DELEGATED DECISION TO DETERMINE PLANNING APPLICATIONS

Reference No:	2026/62/90396/W
Site Address:	75, Lightridge Road, Fixby, Huddersfield, HD2 2HF
Description:	Erection of first floor extension and single storey side extension
Recommending Officer:	Jennifer Booth

OFFICER REPORT

PROPOSED GROUND FLOOR PLAN

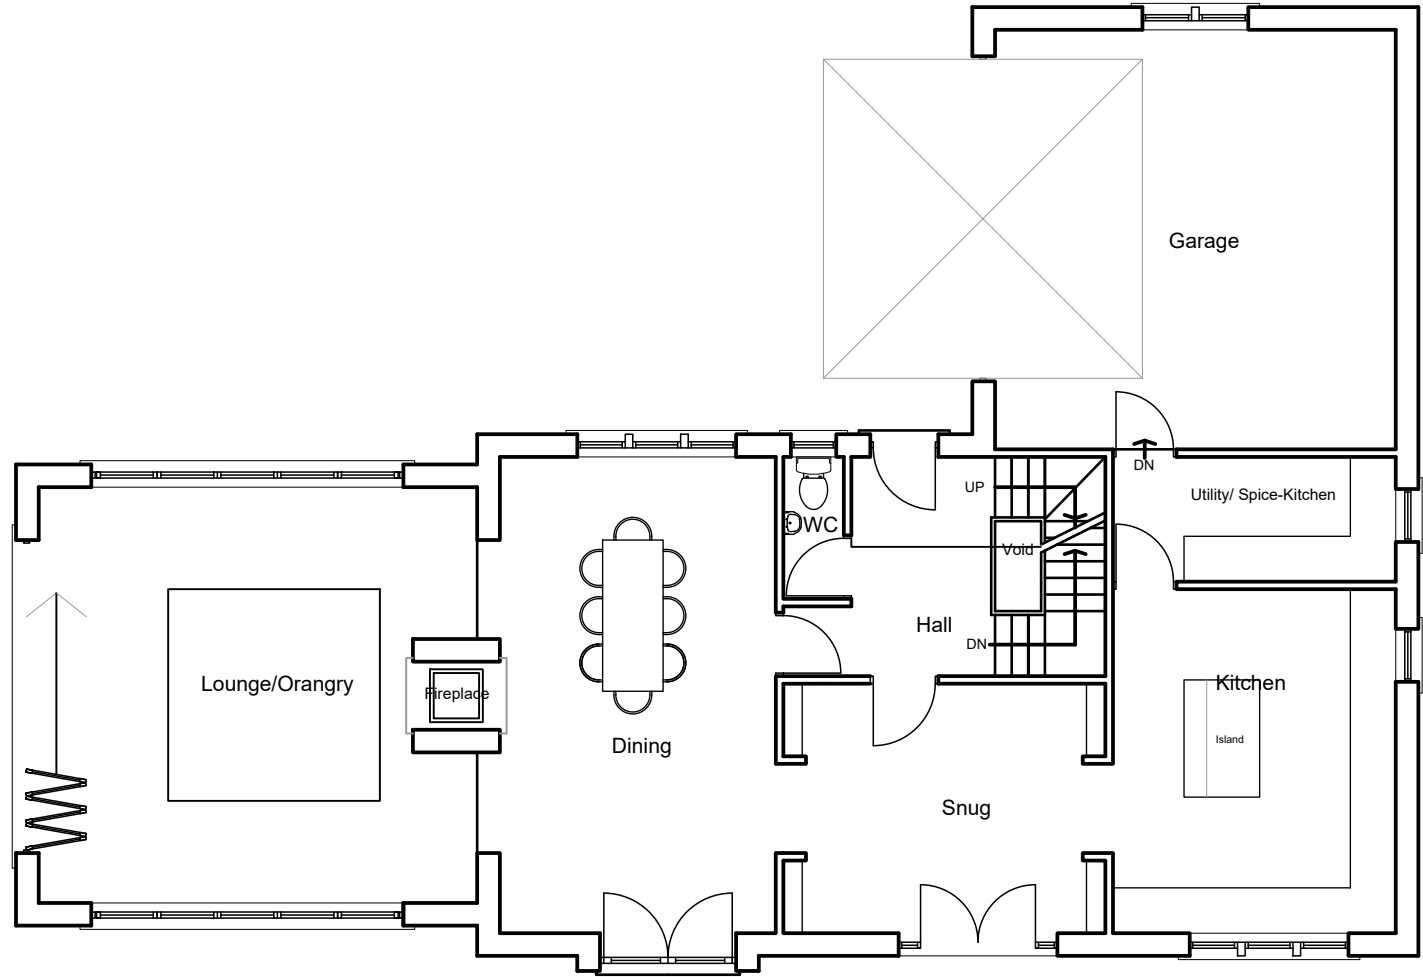
The single storey side extension would be set back 0.5m from the front and rear with a projection of 6m and a depth of 6m. The roof form would be a parapet with a lantern.

The proposed side extension would not result in an unacceptable impact on visual amenity. The property would retain a modest but adequate area of amenity space, and the scale of the extension is therefore considered acceptable and proportionate to the host dwelling. The use of matching materials would ensure the development integrates well with the main house, while the incorporation of a parapet roof would be in keeping with the character of the property and surrounding built form. As a result, the proposal would not appear visually intrusive or harmful to the appearance of the area.

PROPOSED EAST ELEVATION

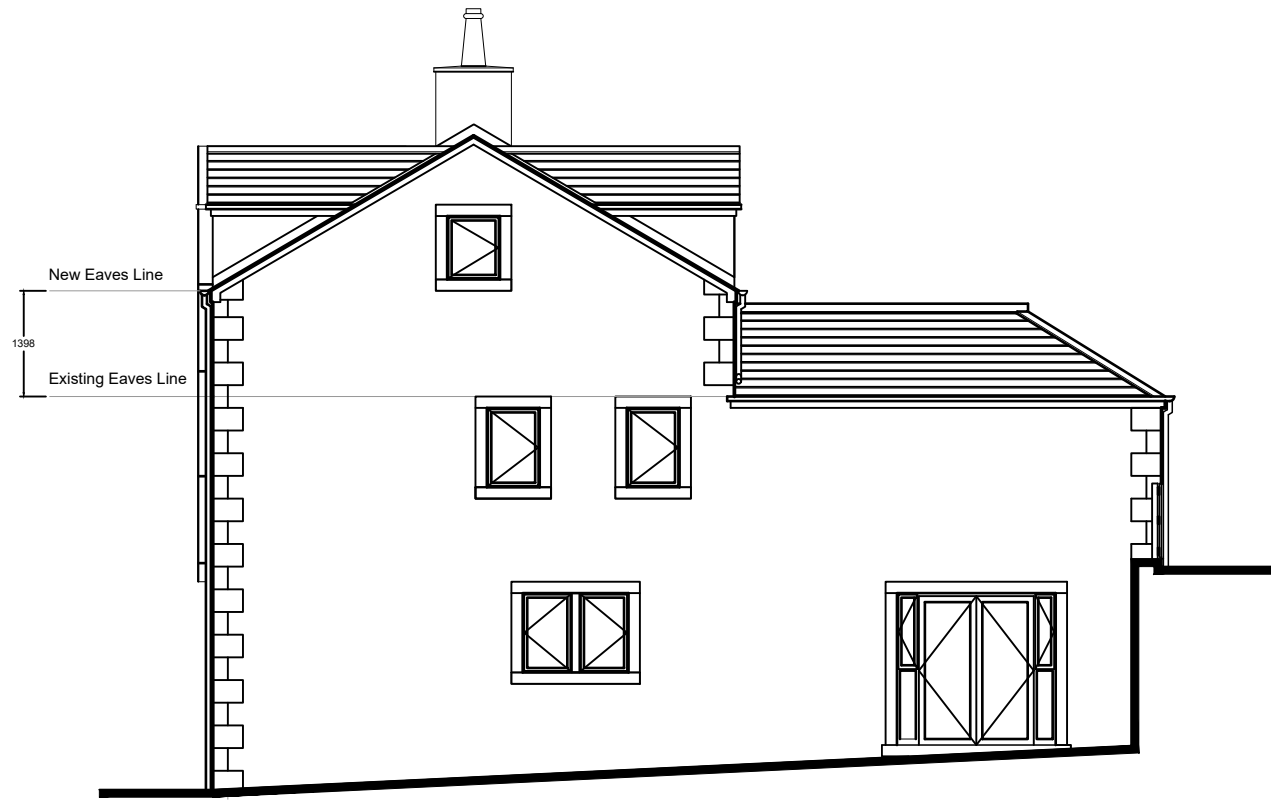
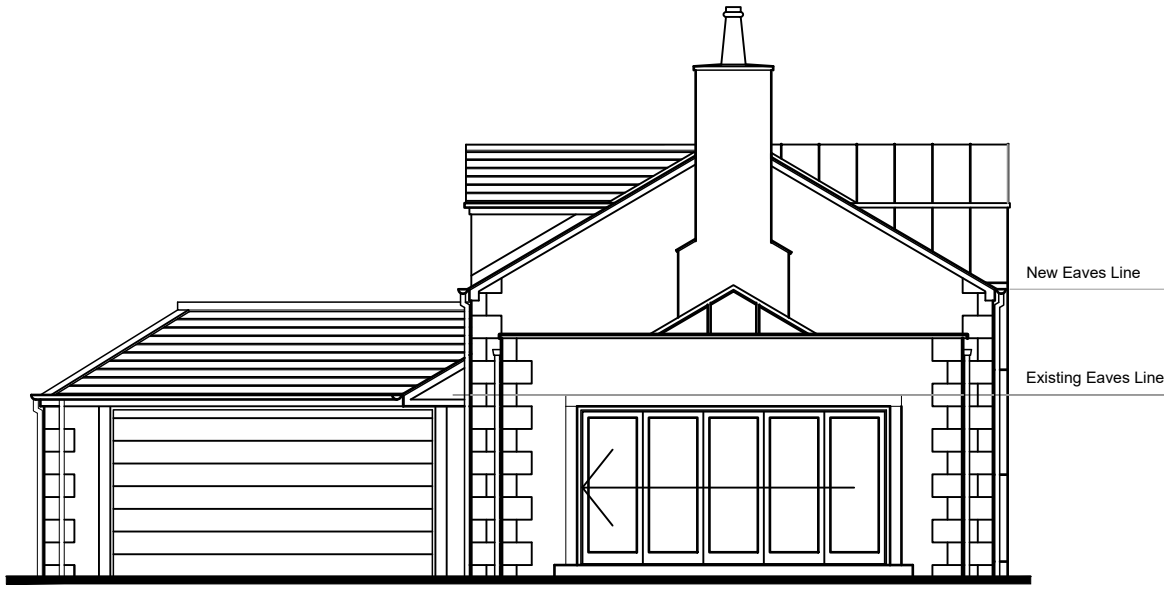
The eaves height would be increased from 2.3m to 3.9m and the overall height would increase from 4.9m to 5.6m with a change from the hipped roof form to a gable roof form with two additional pitched on the front and rear. The rear one would form a Juliet balcony to mirror the one below.

The application site occupies a prominent position within the street scene; however, the proposed increase in roof height would be limited and modest in scale. As such, the development would not appear unduly dominant or visually intrusive. Furthermore, the surrounding area is characterised by a variety of property styles and roof forms, and in this context the proposed alteration to the roof type would not appear out of character. Overall, the proposal would preserve the visual amenity of the area and would not result in harm to the character or appearance of the wider streetscape.
